CITY OF ALBUQUERQUE

January 24, 2022

Re: Pima Medical Institute New Class Room Building
4400 Culter Ave NE
Traffic Circulation Layout
Architect's Stamp 01-03-2022 (H17-D054B)

TITLE
Traffic Circulation Layout - Enlarged Plan

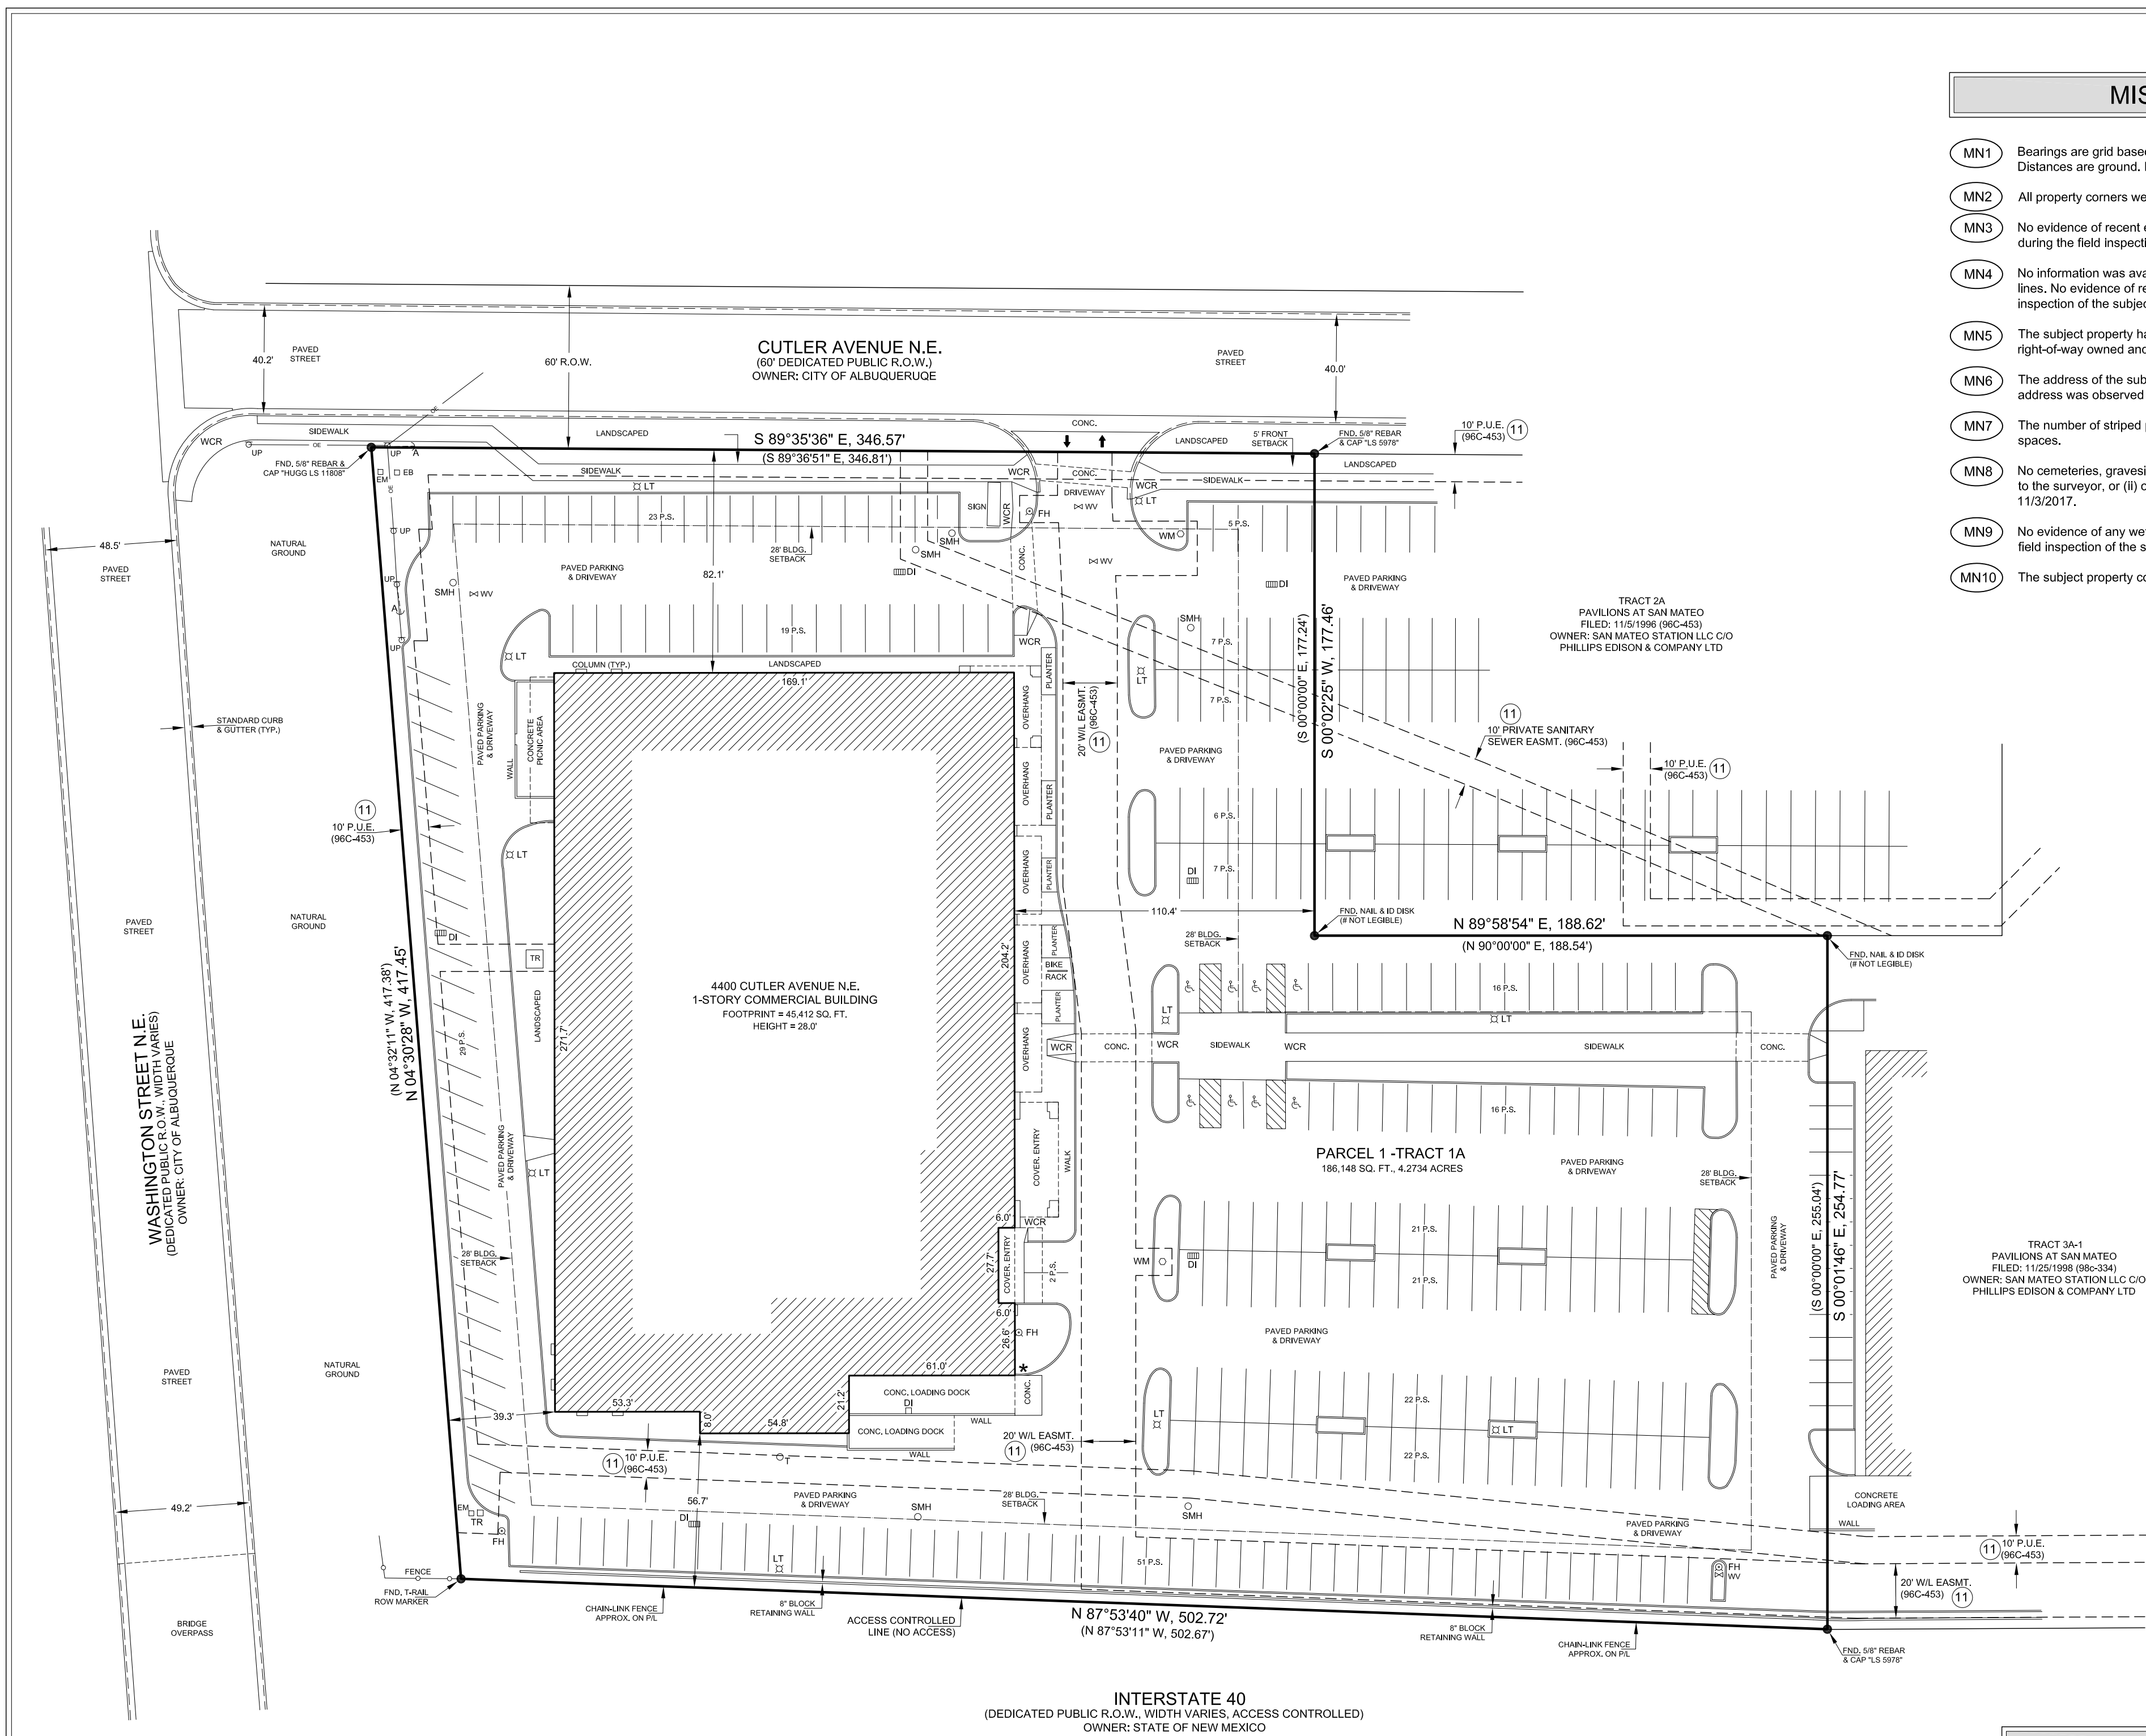
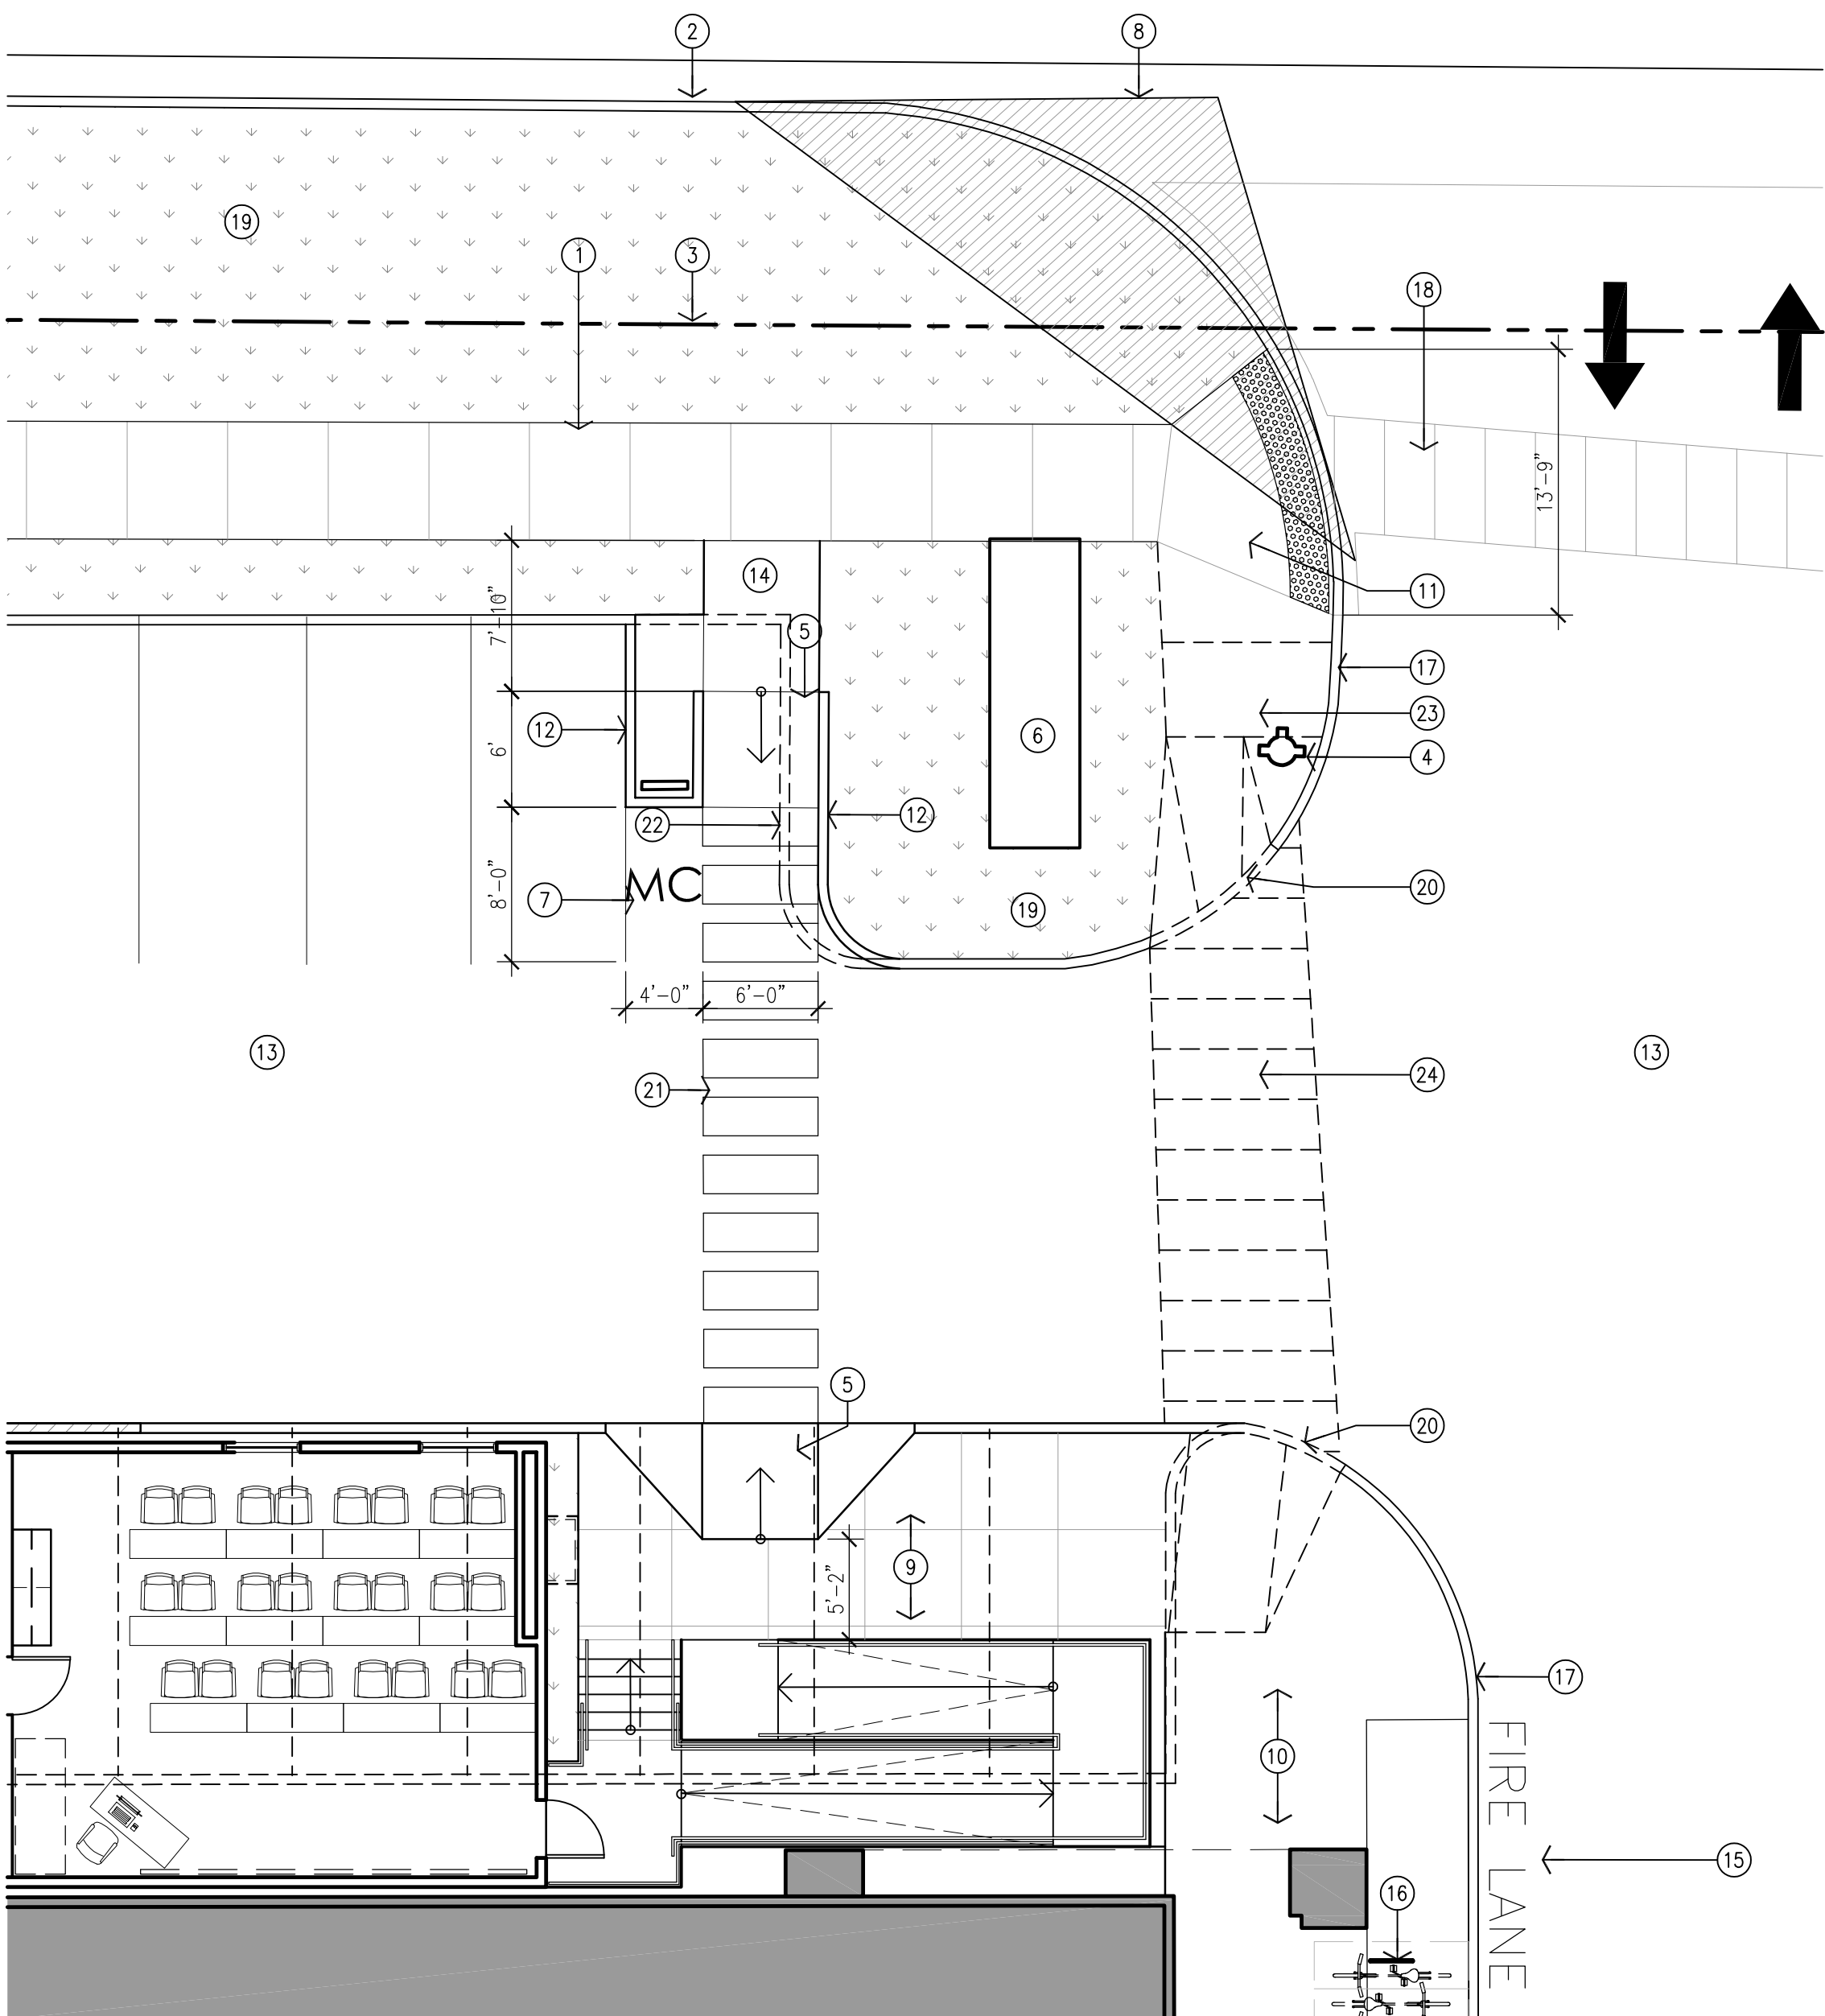
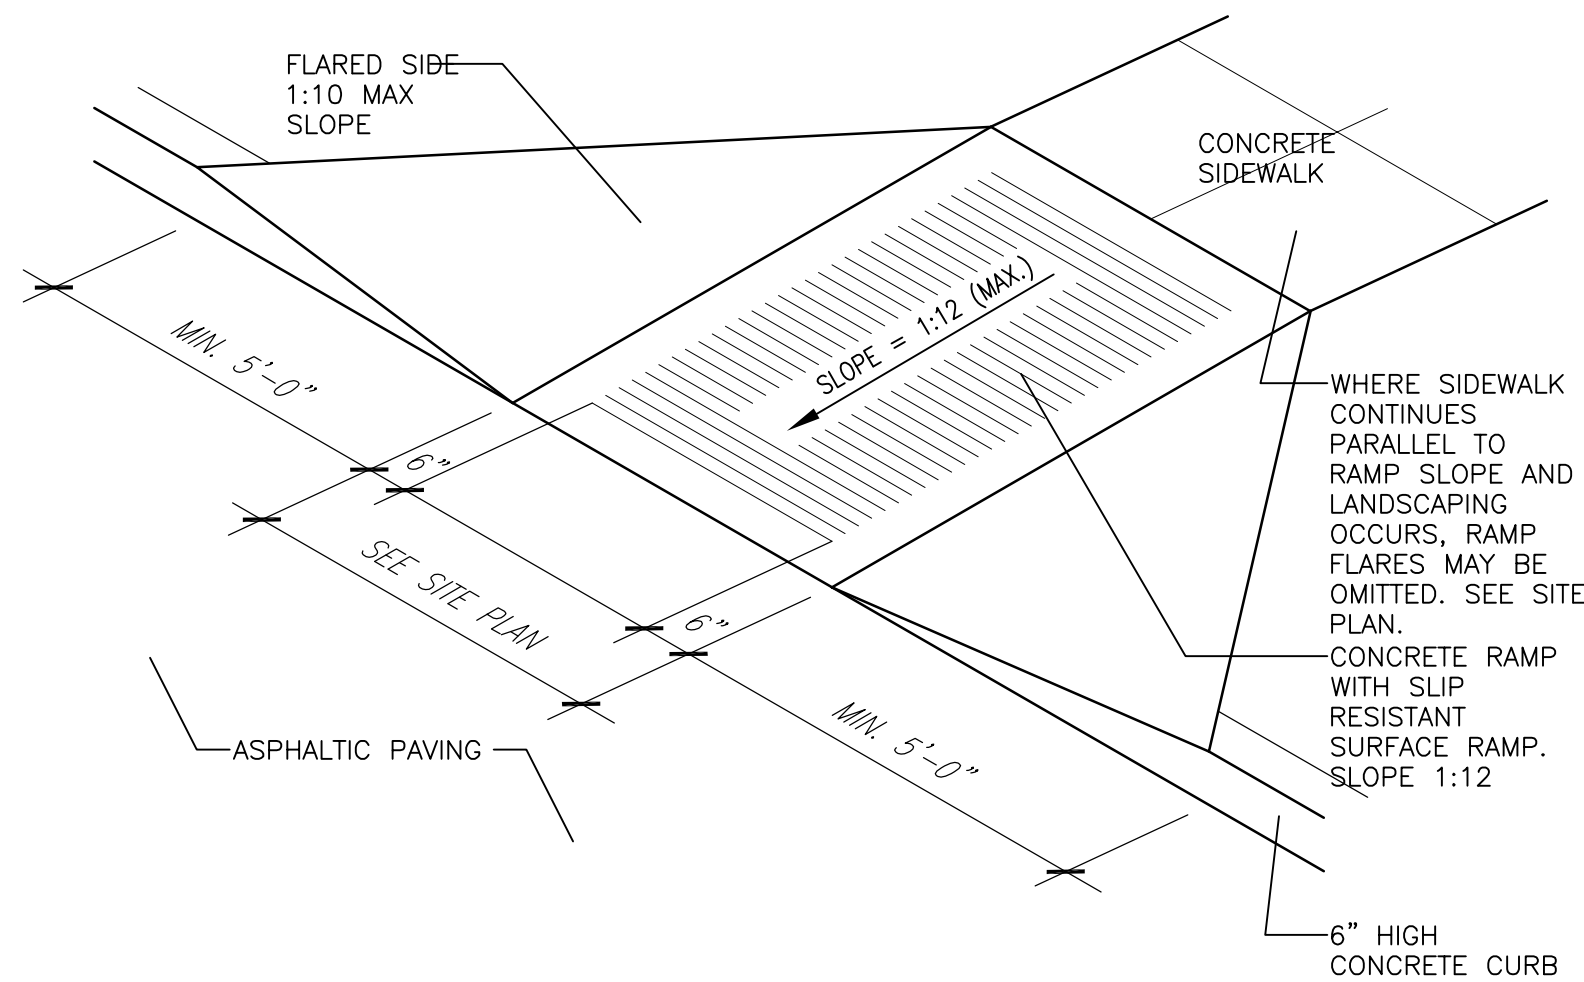
- Verify both existing ramp, at entrance, are update/current ADA . Since you are touching the ramps by modifying the detectable warning surfaces and the existing patterned concrete, and the transitions wings that are not orthogonal to the traffic flow (this makes them non Ada compliant). You will need to replace the ramps.
- The western leg of entrance ramp is in conflict with the existing sidewalk connection onto site since the transition/wing are not orthogonal to the traffic flow. Please replace.
- **Keyed Note 38:** Calls out truncated domes but pattern concrete existing on ramp legs. Will proposed domes complicated the existing patterns which makes it difficult to traverse across these patterns and the addition of detectable warning surfaces.
- **You will need a Sidewalk Easement for existing sidewalk located outside of public ROW. See attachment for the forms.**

- You will need more details on the handrailing including the barrier and edge protection at bottom of railing.
- The landing will need to be 60x60 and label slope 1:48max.
- The run slope will need to read 1:20max.
- How will you provide a update/current ADA ramp adjacent to bike racks when a 6 ft pedestrian pathway will be needed. I suggest you replace the existing ramp for a current ADA accessible design and provide from that point to the entrance 6 ft width of pathway (CLEAR from ramp to entrance).
